**Re: Comment Letter for Proposed Redevelopment of 6950 SE Maker Street
Permit No. 2207-019**

On behalf of our client, Dan Grove, we submit these comments on the permit application for the proposed demolition and rebuild of the home located at 6950 SE Maker Street (the “Strand Property”) pending under Permit No. 2207-019 (the “Permit”). Mr. Grove owns the house immediately adjacent to the east of the Strand Property and is acutely familiar with the issues discussed in this letter. Mr. Grove respectfully requests notice and a copy of the permit decision once made by the City.

JOB NUMBER:	210007
DATE:	05/27/2021
DRAFTED BY:	RSN
CHECKED BY:	TBR / JGM
SCALE:	1" = 10'
REVISION HISTORY	
SHEET NUMBER	1 OF 1

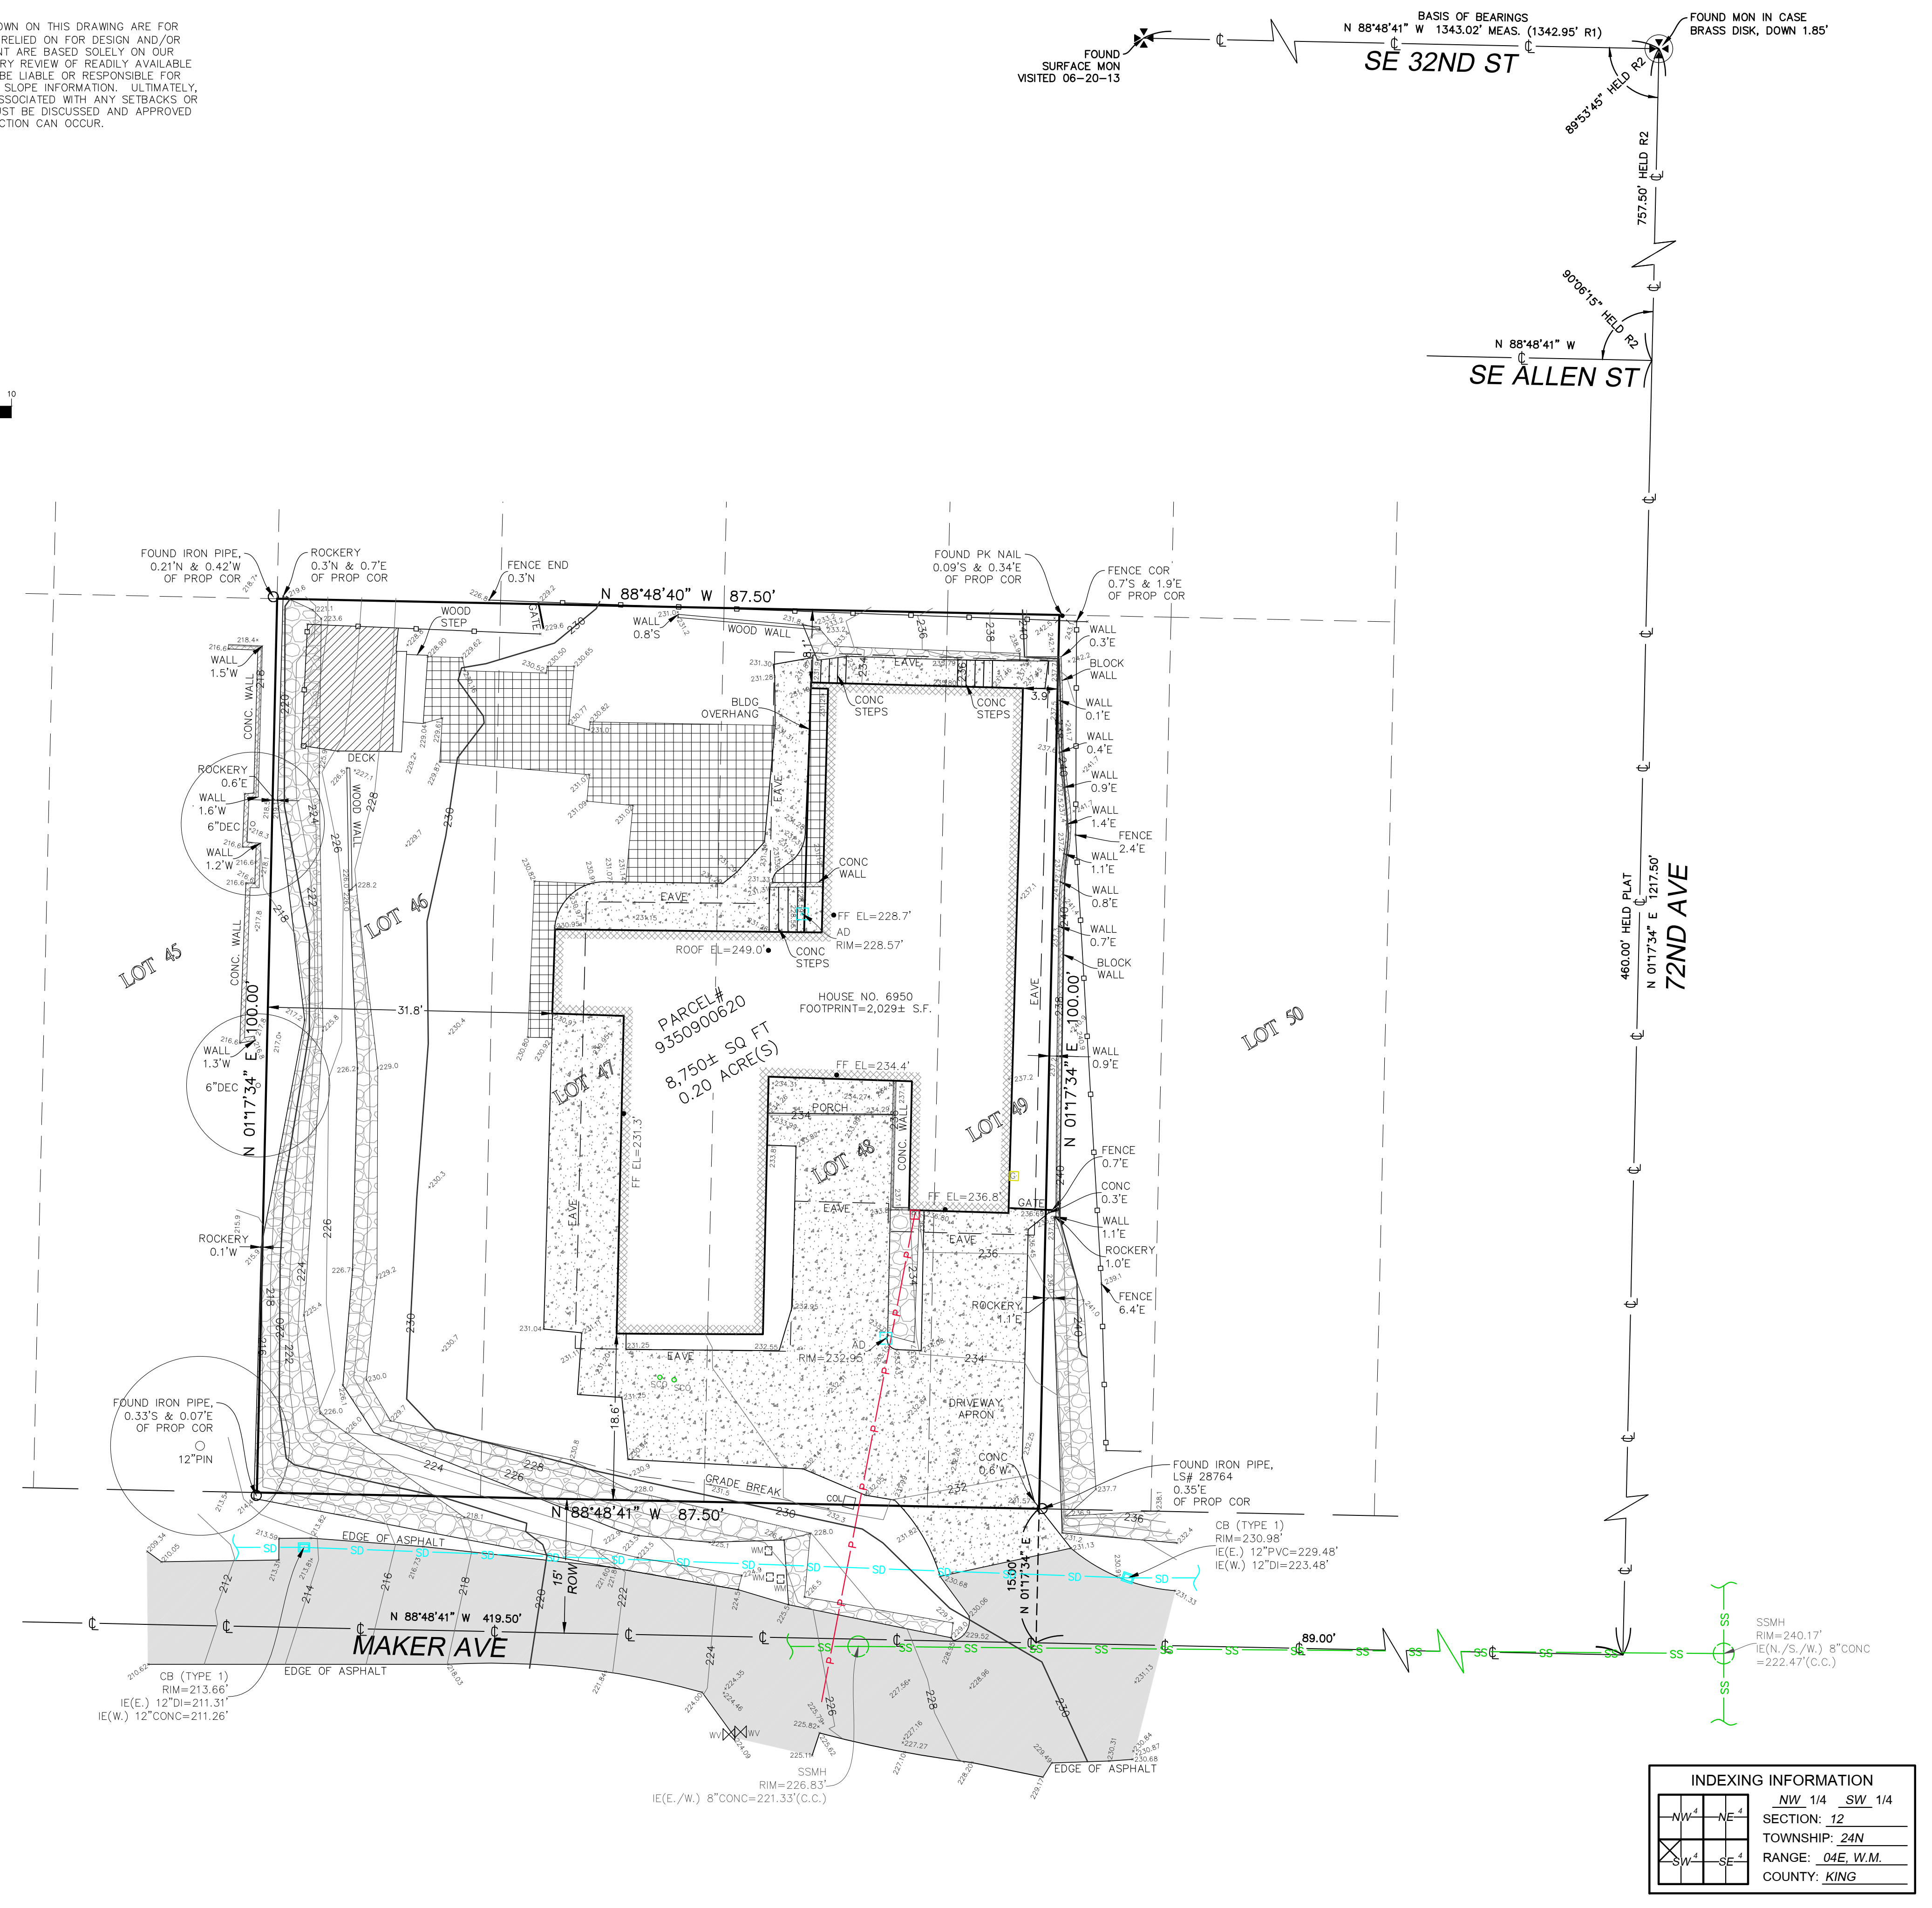
finished floor elevation of the basement as 228.7' (Sheet 1), the proposed finished floor elevation as 227.72' (Sheet C-2), and the existing grade as 235.24' (Sheet A3.1).
